An
Bord
Pleanála

Inspector's Report

ABP-314934-22

Development	Mixed use commercial development consisting of a hotel, office block, and all associated site works.
Location	Heuston South Quarter, bounded by St. John's Road West (to the north), Military Road (to the east) and the Royal Hospital Kilmainham (Protected Structure) (to the west and south), Kilmainham, Dublin 8.
Planning Authority	Dublin City Council
Planning Authority Reg. Ref.	4610/22
Applicant(s)	HPREF HSQ Investments Limited
Type of Application	Permission
Planning Authority Decision	Refuse
Type of Appeal	First Party vs. Refusal
Appellant(s)	HPREF HSQ Investments Limited
Observer(s)	1. Frank McDonald 2. Paul D. Leech
Date of Site Inspection	4th October 2023
Inspector	Stephen Ward

Figure 15.3.4.1 Fig 27 (DCC Development Plan 2016-2022) SDRA 7 Showing 'Cone of Vision'

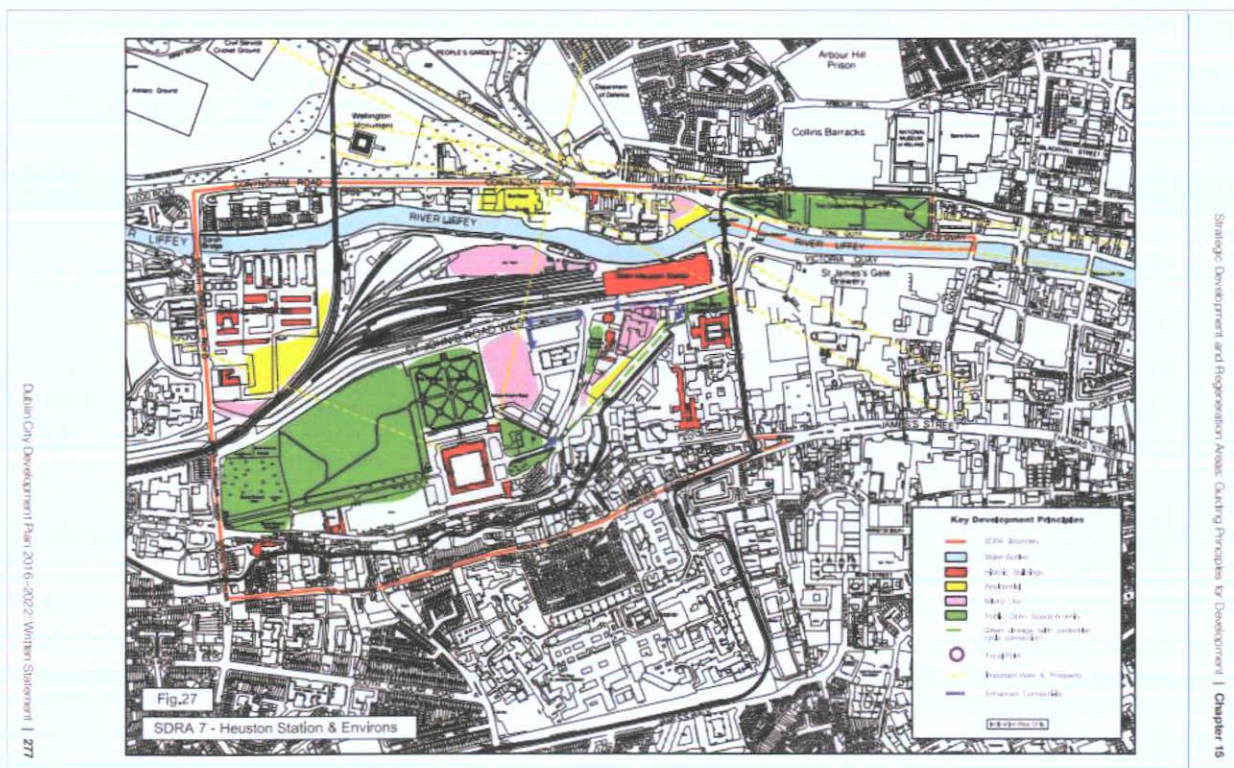
2. The proposal would by reason of visual intrusion, adversely affect the identified Cone of Vision view which runs from the northeast corner of the Deputy Master's House to the southeast edge of the main facade of the Dept. of Defence/Royal Infirmary. The proposed development would therefore be contrary to Section 15.1.1.10 (8) of the Dublin City Development Plan 2016-2022 which seeks to ensure that new development within the designated 'Strategic Development and Regeneration Area (SDRA) 7 - Heuston Station and Environs Area', does not adversely affect views within this cone. The proposed development would therefore be contrary to the proper planning and sustainable development of the area.

- The 'cone of vision', as set out in the Heuston Framework Plan and the City Development Plan, represents a significant view between the RHK and Phoenix Park, and the Development Plan (s. 15.1.1.10 (8) and Guiding Principle 8 of SDRA 7) stipulates that any new developments within this 'cone' shall not adversely affect this view. The cone is not accurately represented in the applicant's Heritage Impact Assessment. The proposed development would adversely affect the cone of vision to and from the RHK and would be contrary to the Development Plan.
